Stonestreet Green Solar

Appendix 1.2: EIA Scoping Opinion

Proposed Stonestreet Green Solar

30 May 2022

Document Name:
Environmental
Statement Figure 9.5:
East Stour River
Proximity Plan
- Sheet 3 of 3

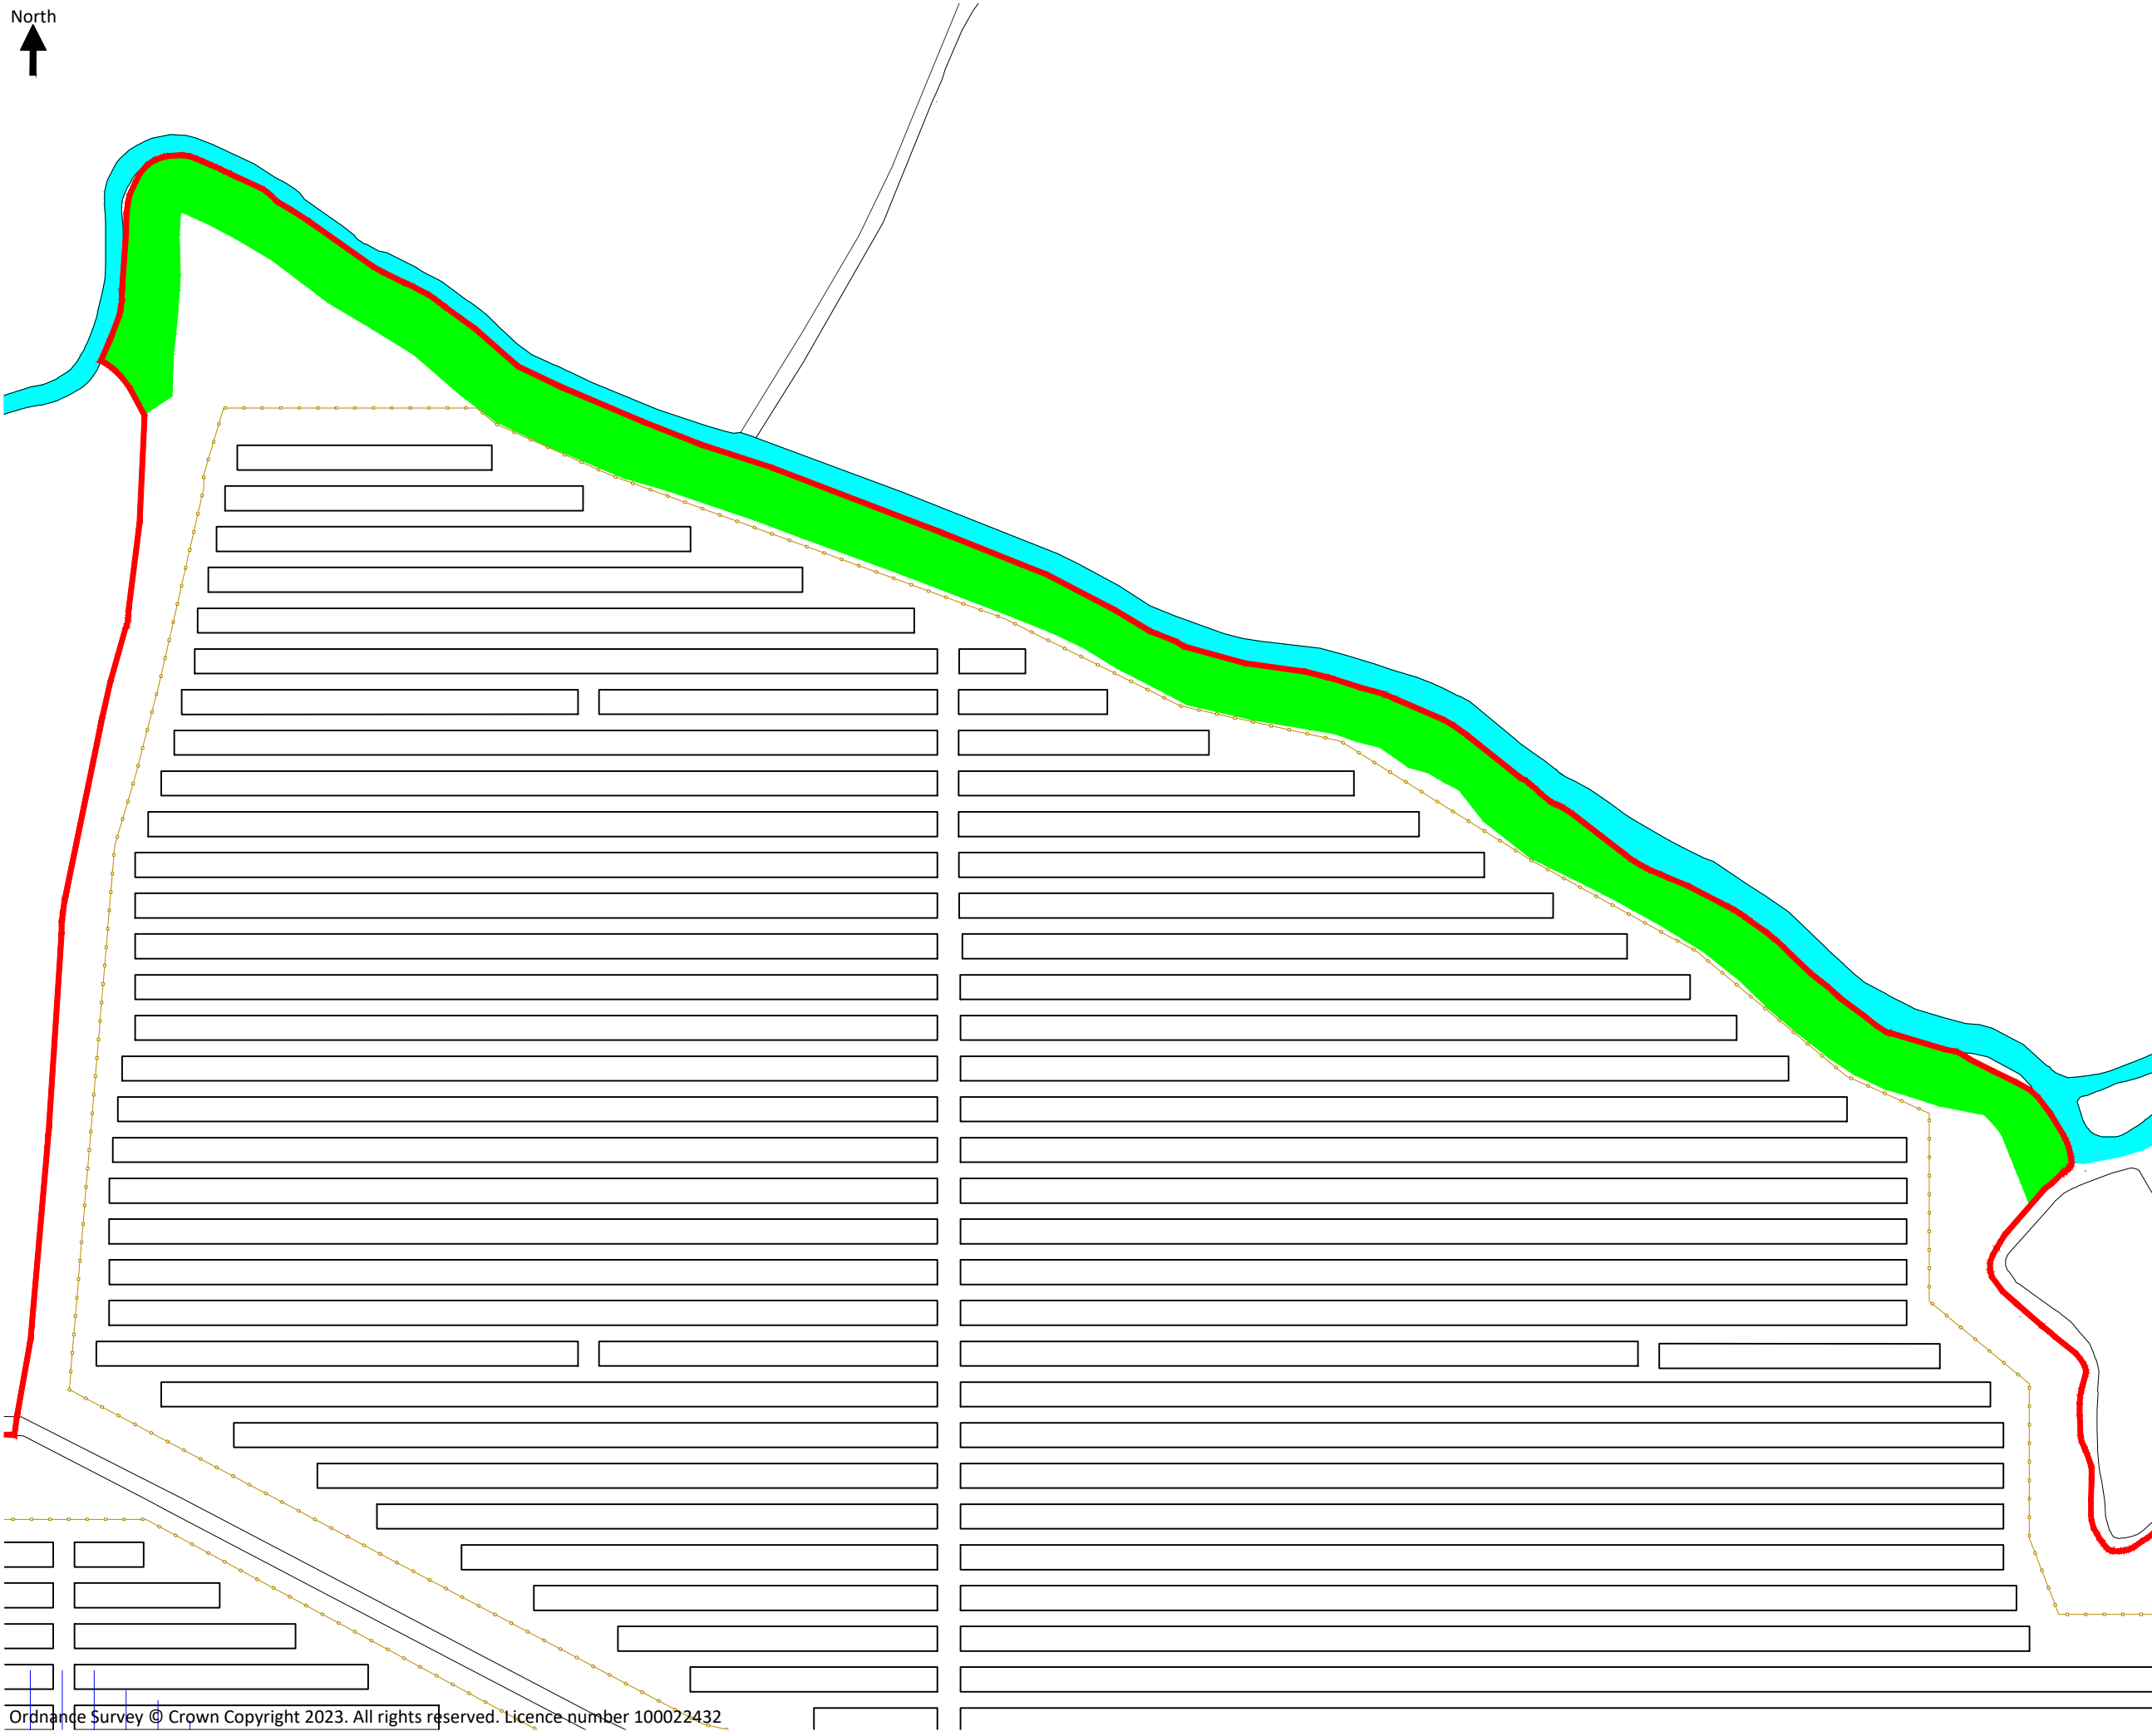
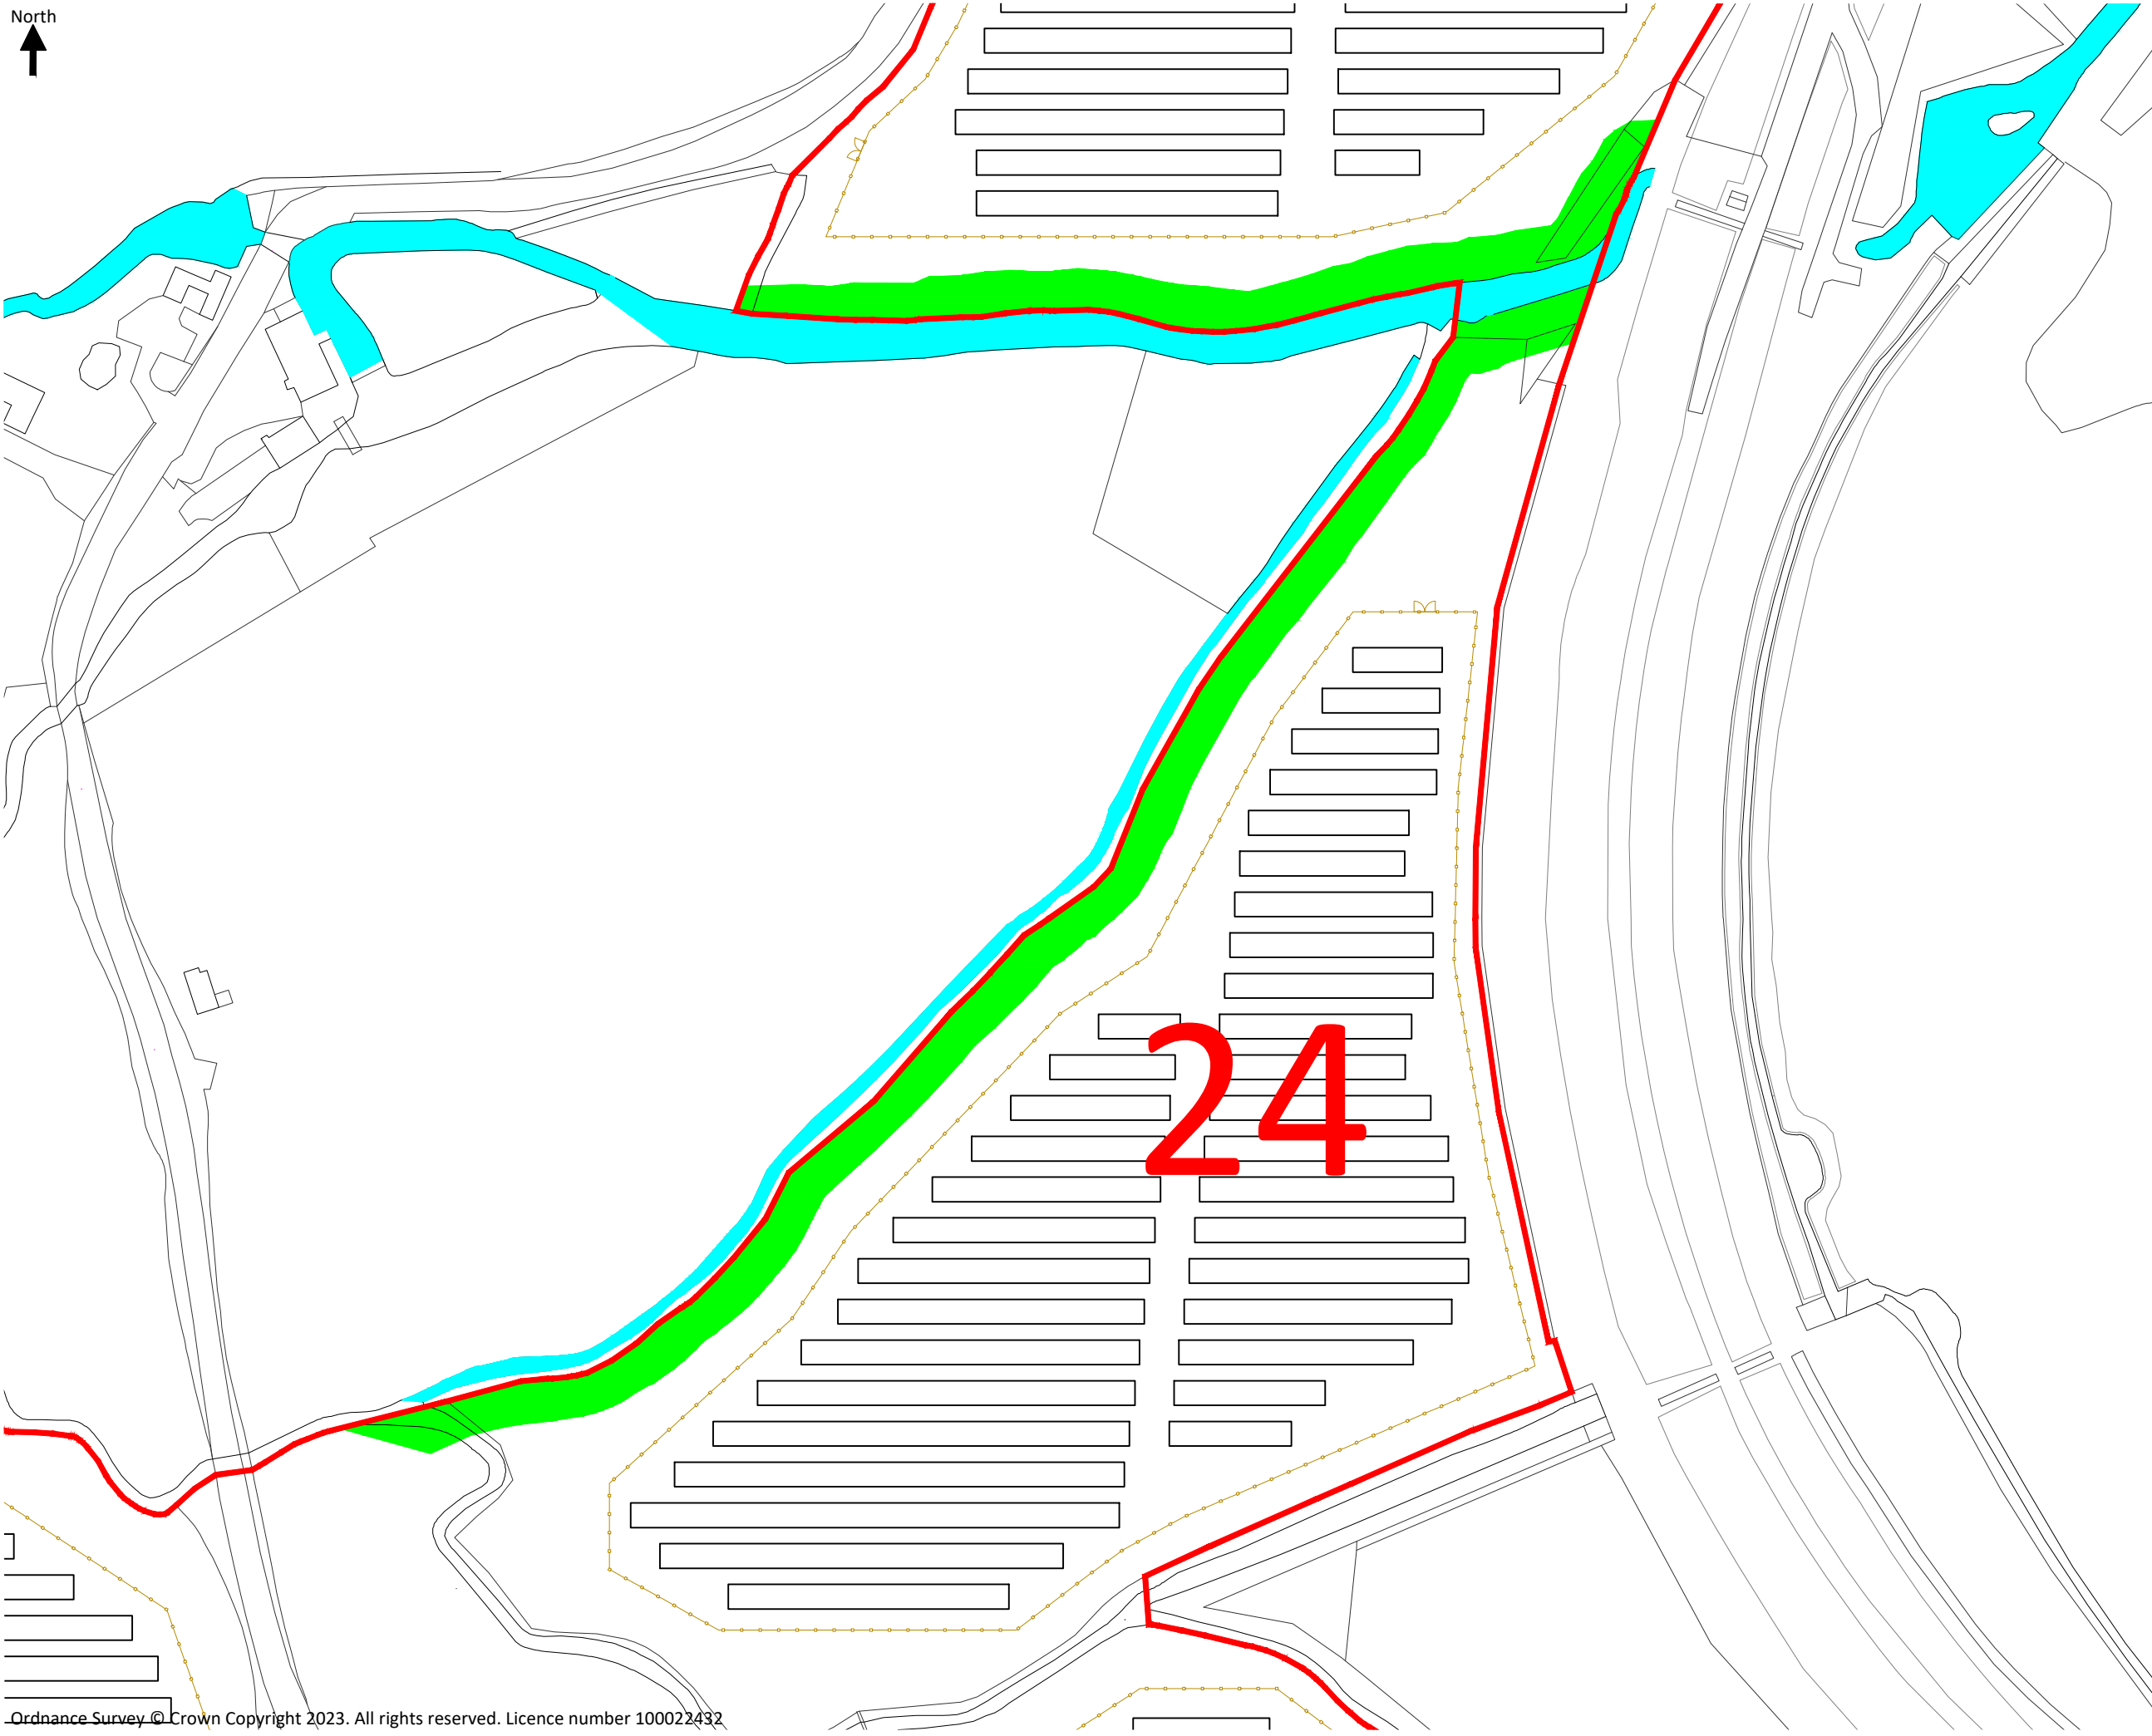
3.4.6	10.7.9, 11.3.3, 11.3.2, 11.5.1 and Table 10.3	East Stour River habitat of Principal Importance	<p>Figure 12 and paragraph 1.4.5 identify that the East Stour River runs directly through the solar array site. Scoping Report paragraph 10.7.9 proposes to scope out impacts to the East Stour River on the basis that standard construction measures secured through the CEMP will afford physical protection and pollution prevention and control; this includes a 10m standoff distance between any built development and watercourses and pollution control measures.</p> <p>Scoping Report paragraphs 11.3.2 and 11.5.2 state that there is potential for watercourse crossings but these are not described in the project description and it is unclear whether potential crossings are for vehicles, cable routing etc. Without details of what crossings are proposed, the Inspectorate cannot agree to scope out consideration of impacts on the East Stour River.</p>

ID	Ref	Applicant's proposed matters to scope out	Inspectorate's comments
			The ES should describe and locate all proposed watercourse crossings and assess associated impacts where significant effects are likely to occur.
